WEST SUSSEX COUNTY COUNCIL CONSULTATION

TO:	Arun District Council FAO: Simon Davis
FROM:	WSCC - Highways Authority
DATE:	31 October 2019
LOCATION:	Clinton Carpets Ltd, 5 Victoria Drive, Bognor Regis, PO21 2RH
SUBJECT:	BR/280/19/PL Redevelopment of existing retail site to a mixed use development comprising a single ground floor retail unit with 5 residential units at first, second and third floor levels.
DATE OF SITE VISIT:	N/A
RECOMMENDATION:	Advice
S106 CONTRIBUTION TOTAL:	N/A

DRAWING TITLE
PROPOSED SITE PLAN
AND BLOCK PLAN

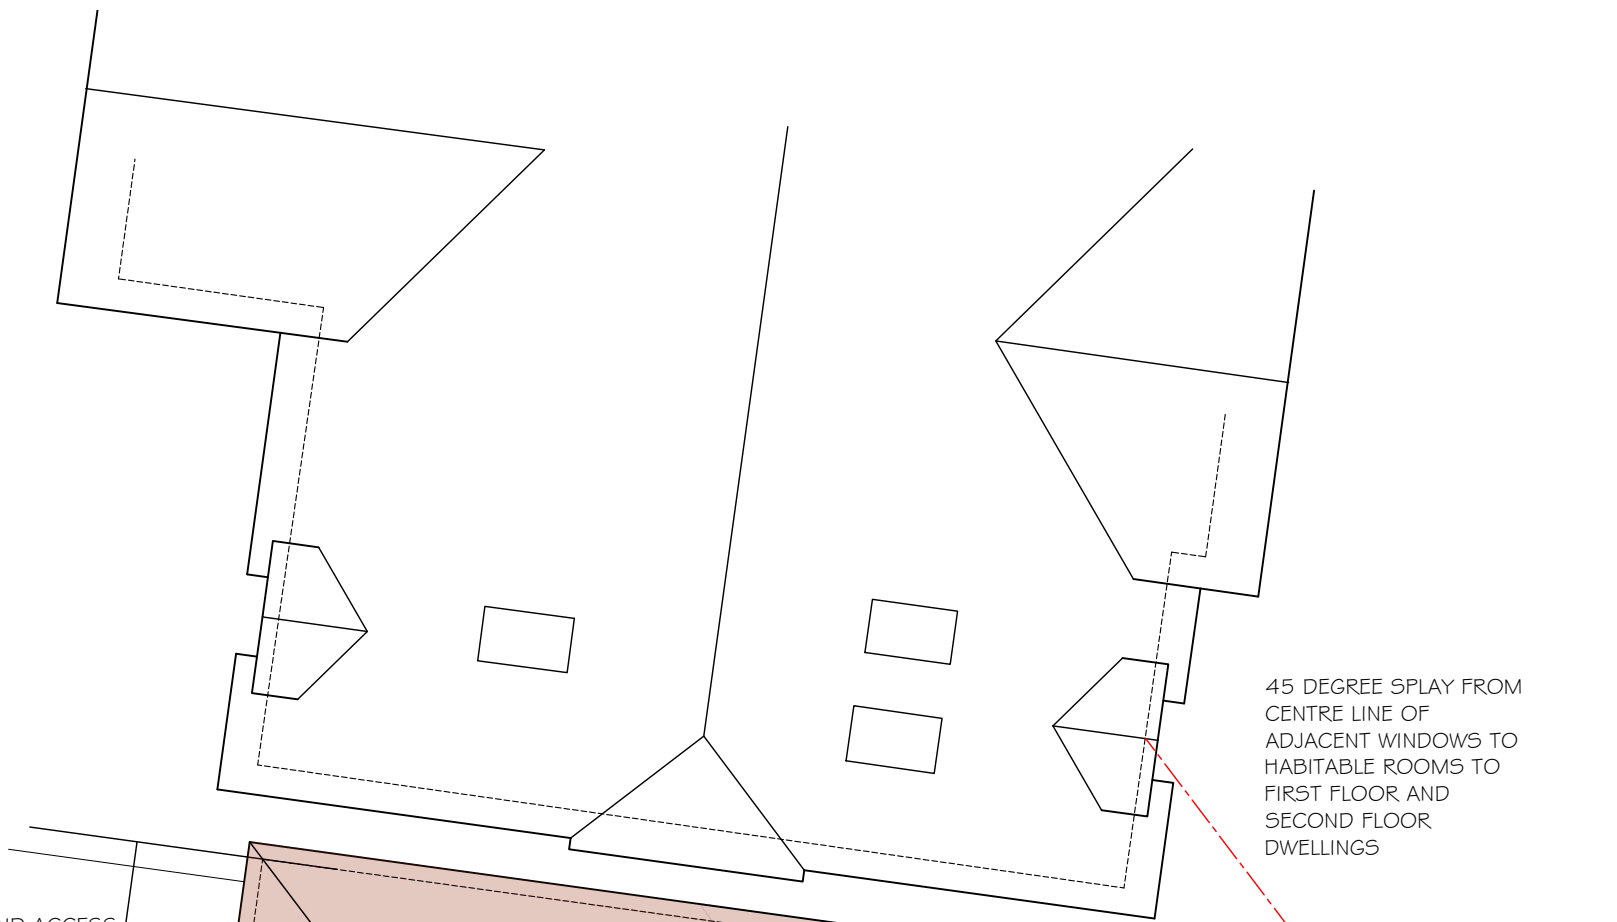
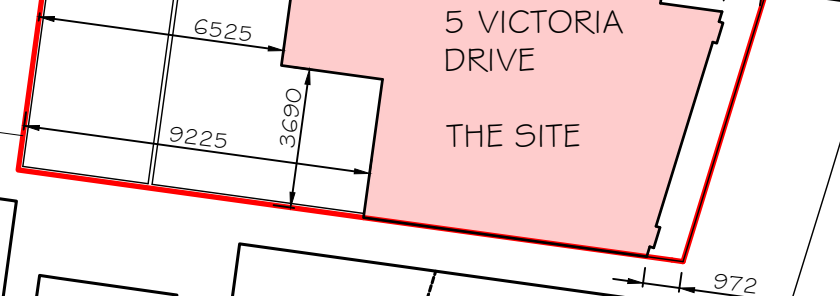
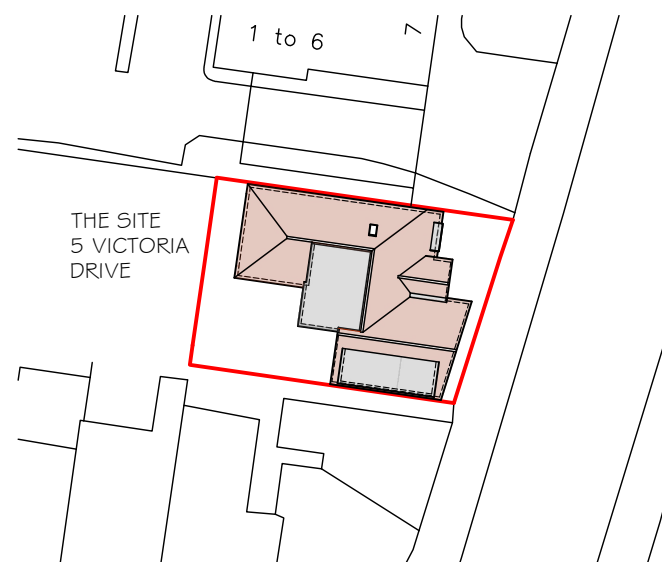
Cycling is a viable option in the area. A cycle store with space for 5 cycles has been demonstrated in the plans. Under WSCC parking standards, at least 1 cycle space should be provided per 1-2 bedroom dwelling. The proposed cycle parking provision is therefore considered sufficient for this development. The inclusion of secure and covered cycle parking helps promote the use of sustainable alternative modes of transport to the private car.

No part of the development shall be first occupied until covered and secure cycle parking spaces have been provided in accordance with plans and details submitted to and approved by the Local Planning Authority.
